Recommendation Report for Planning Permission for Works or Extension to a Dwelling

REF NO: EP/126/20/HH

LOCATION: 56 Angmering Lane
East Preston
BN16 2TA

PROPOSAL: Resubmission (EP/37/20/HH) of proposed extensive refurbishment of existing 2-storey dwelling to include, single storey side/rear extensions, 2-storey rear extension, roof extension and front double garage

PROPOSED EAST ELEVATION 1:50

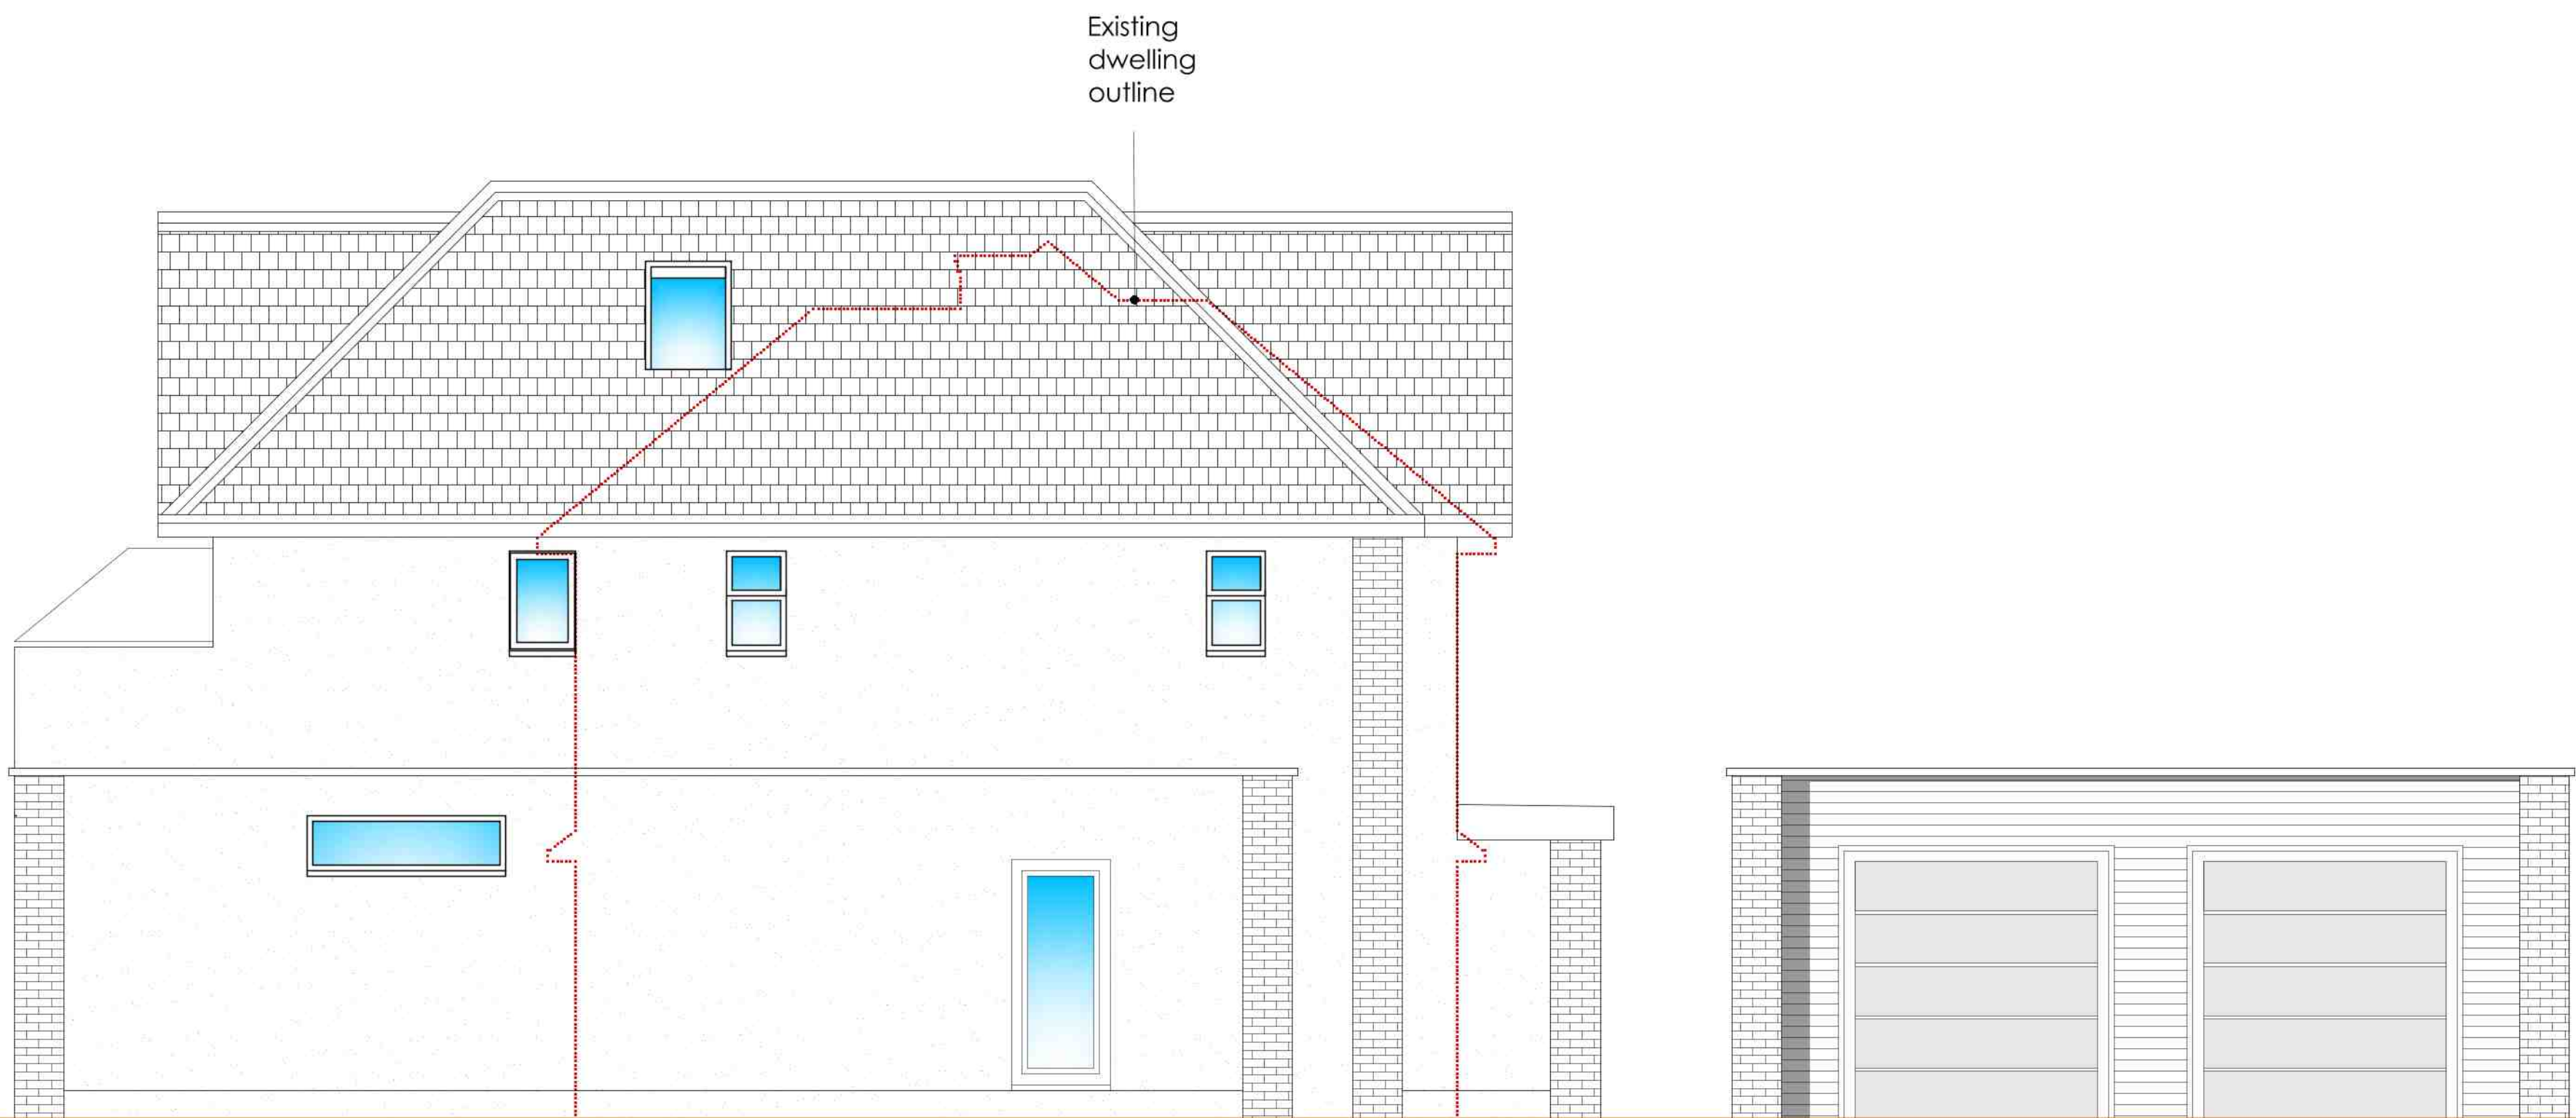
The proposed development is not considered to result in any significant impact upon the residential amenities of neighbouring dwellings by way of overshadowing or overbearing impact. At ground floor level, the proposed development increases the distances between the host dwelling and the Northern boundary of the application site. To the South, the element of which has potential for harm is the proposed garage, however, as this is 'tucked' into the corner of the site, it is not considered to result in an unneighbourly impact on adjacent occupiers. The proposed two storey rear extension, whilst 5m from the Southern boundary of the application site, does not result in an unneighbourly impact. This is because on the other side of the boundary there is a single storey garage, which features no openings which give rise to potential for harm.

The proposed development proposes a variety of new openings, therefore, potential for loss of privacy as a result of the application should be assessed. The proposed openings on the Western elevation of the host dwelling face towards the street scene, and as such are not considered to result in any overlooking impact. To the North, there are no views that are considered to be harmful. The proposed window to Bedroom 3 overlooks the front driveway of the neighbouring dwelling which is visible from the public realm. The proposed openings along the Northern element of the balcony, and the window serving Bedroom 3's en-suite are not considered to result in harmful overlooking of the adjacent property, as they both provide views towards the roof slope of the adjacent dwelling. To the East, the proposed development is not considered to provide any views of which are unavailable from the host dwelling at current, this is because the majority of the views available are within the application site itself. To the South, the development is not considered to result in any change in views available, the Southern facing window sited on the two storey rear extension is stated as being at a high level, which does not allow for

PROPOSED WEST ELEVATION 1:100

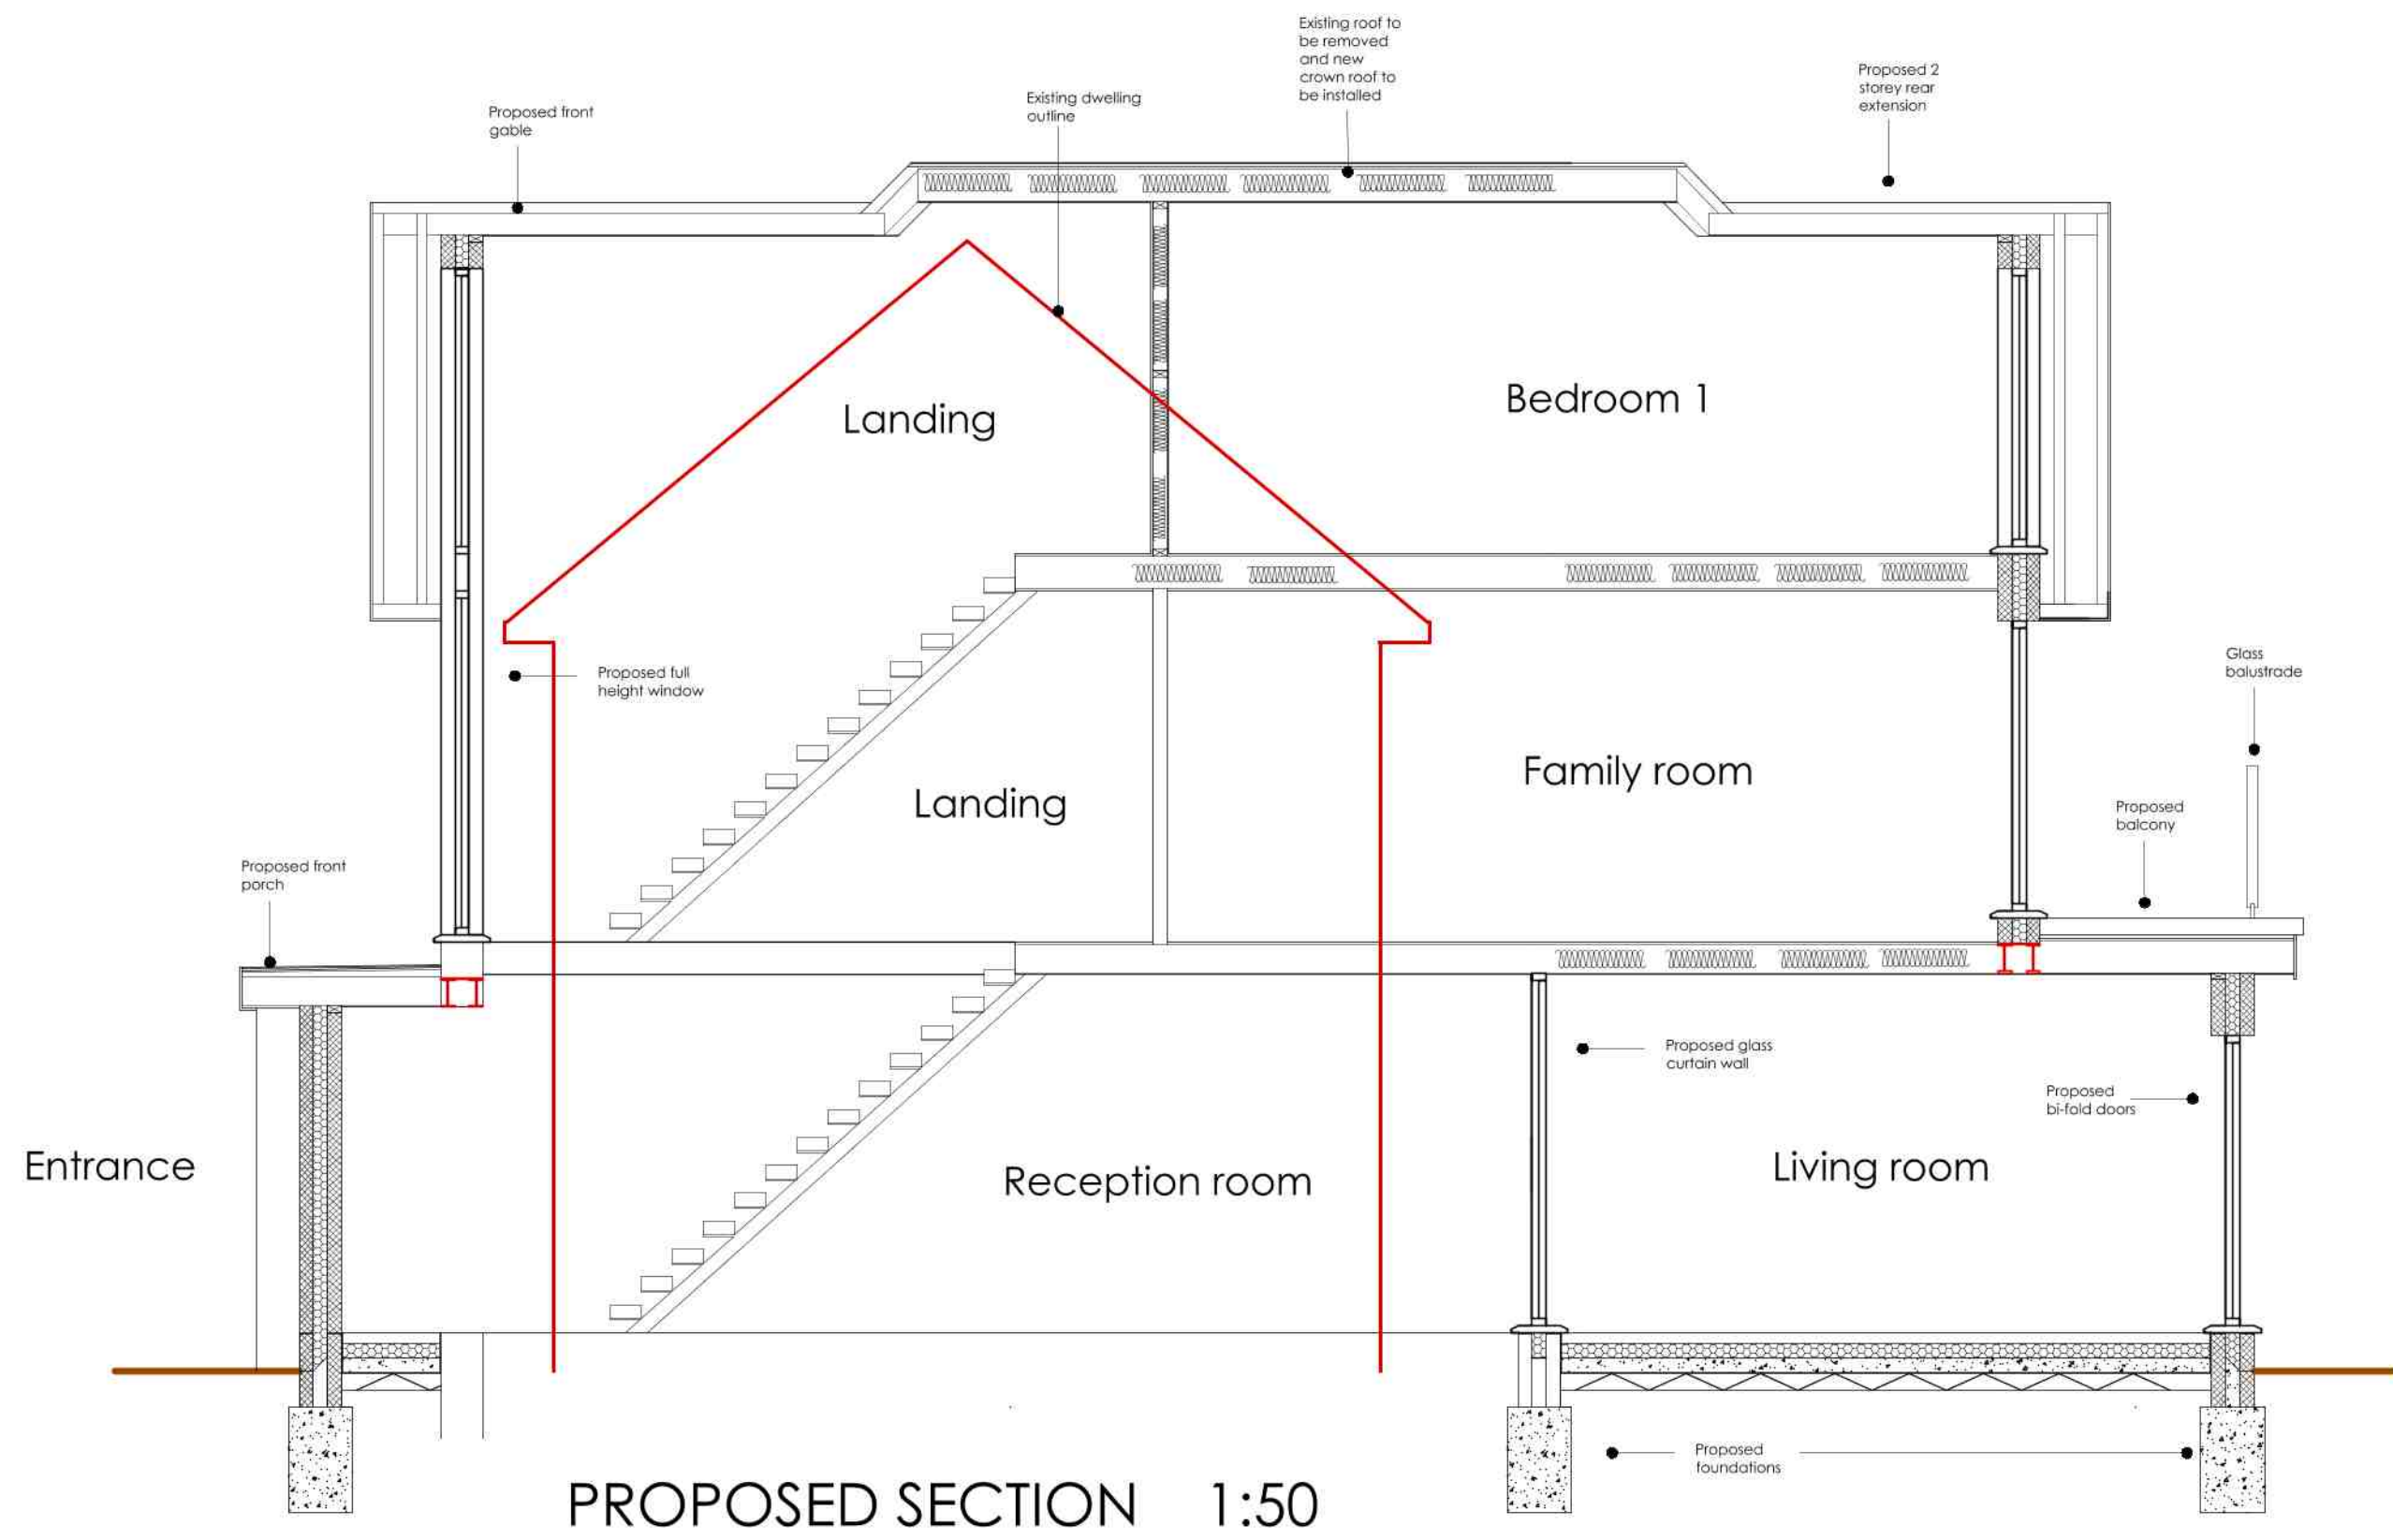
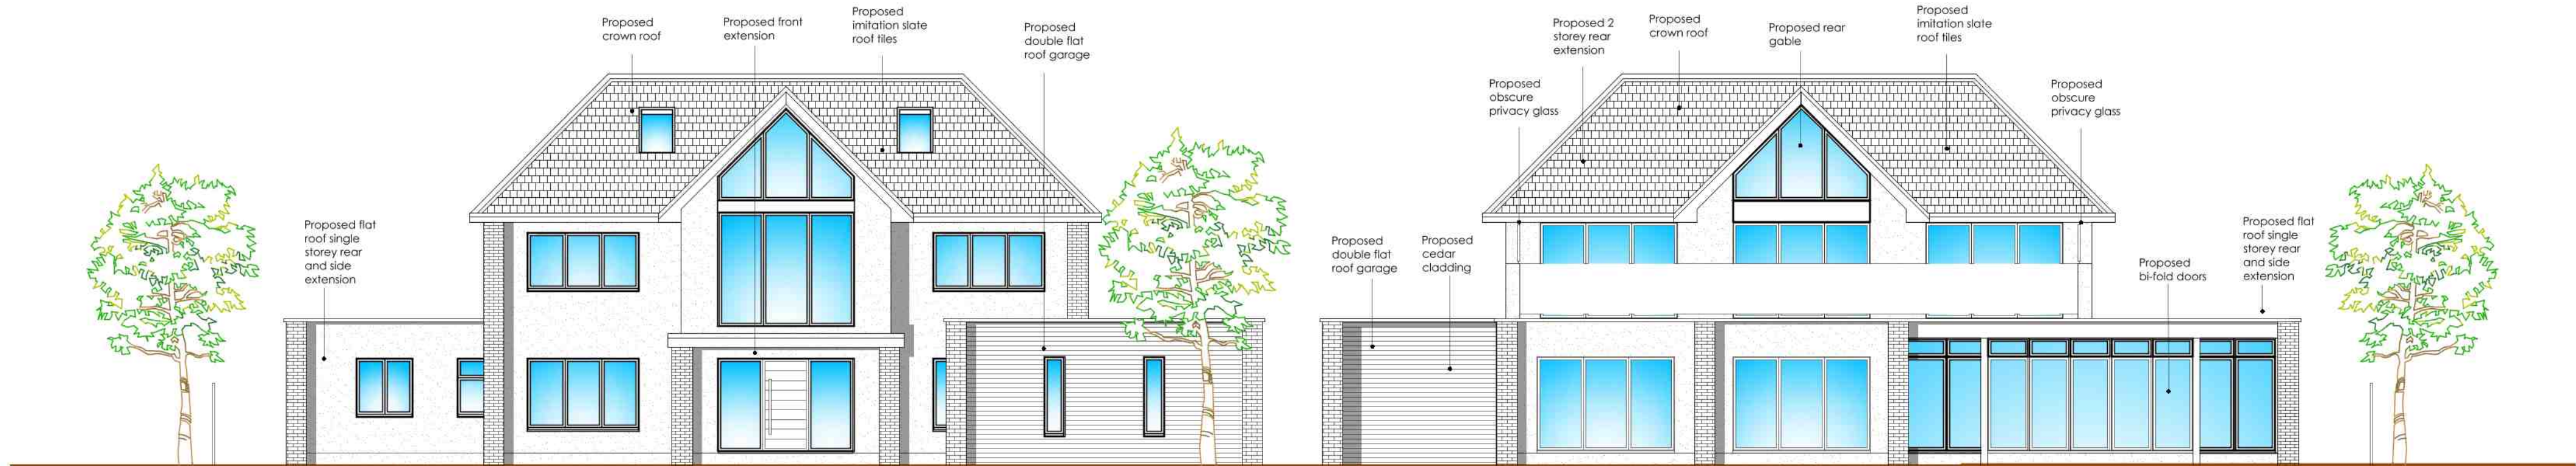
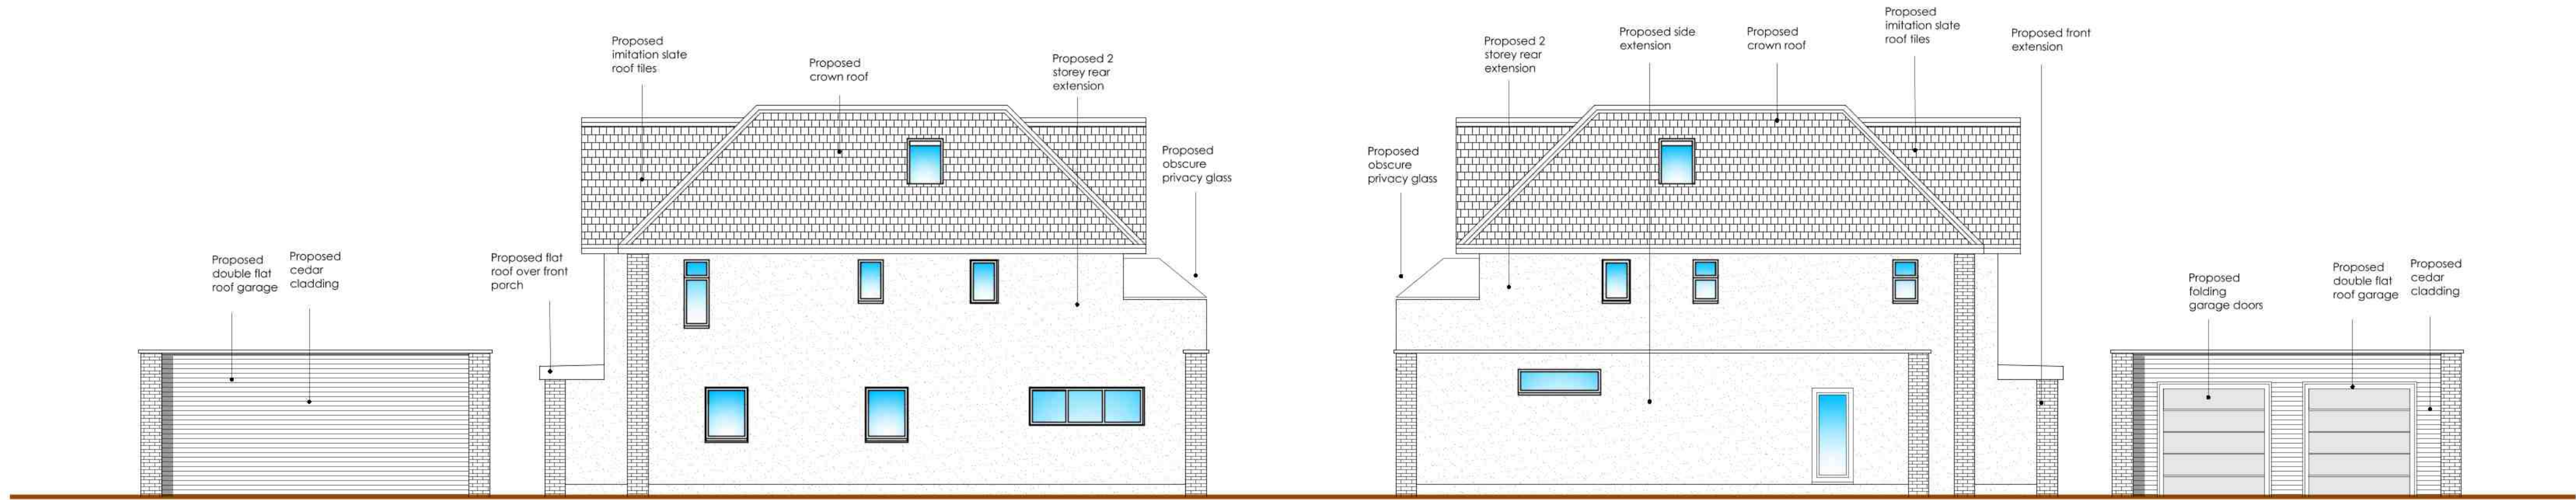
This application follows previously refused application EP/37/20/HH, however, it is of an altered design. This change primarily relates to the way that the third storey is achieved as opposed to the creation of a full third storey, the application utilises the conversion of the roofspace.

The proposed extensions and alterations to the host dwelling are not considered to be sympathetic to the appearance of the host dwelling, or visually subservient to its existing appearance. However, this is not considered to be reason alone for refusal of the application as the proposed dwelling as it would need to be established that the proposal would have a detrimentally harmful impact upon the character of the host dwelling, or its locality. The locality is host to a wide variety of dwelling designs, styles and uses of materials. There are dwellings within the area which have similar design features to the proposed development, and as such, the proposed development cannot be considered to appear incongruous or

overly dominant within the street scene. Additionally, the use of a crown roof allows for a more consistent spatial pattern along the street.

The previous application refused the application due to the harmful impact of the addition of a full third storey, of which was considered to appear bulky and unattractive. However, as was stated in the previous application, it was the visual appearance of the third storey of which was considered to result in harm, not its principle. The proposed development seeks to make alterations to the roof of the host dwelling, including a height increase of approximately 0.56m. It is noted that a loft conversion and addition of a rear dormer can be performed under Permitted Development, however, this is not within the control of the Local Planning Authority. Part 4.14 of Policy 1 of the East Preston Neighbourhood Development Plan seeks to resist buildings being altered to have more than two storeys, and intends that dormer windows should be subservient to the appearance of the roof as a whole. The host dwelling is currently two storeys, and as a result of the proposal, will likely be considered to be three due to the conversion of the roofspace. The proposed development however is not considered to conflict with this policy, in that the creation of another storey in the roofspace could be performed under Permitted Development, without need to contact the Local Planning Authority.
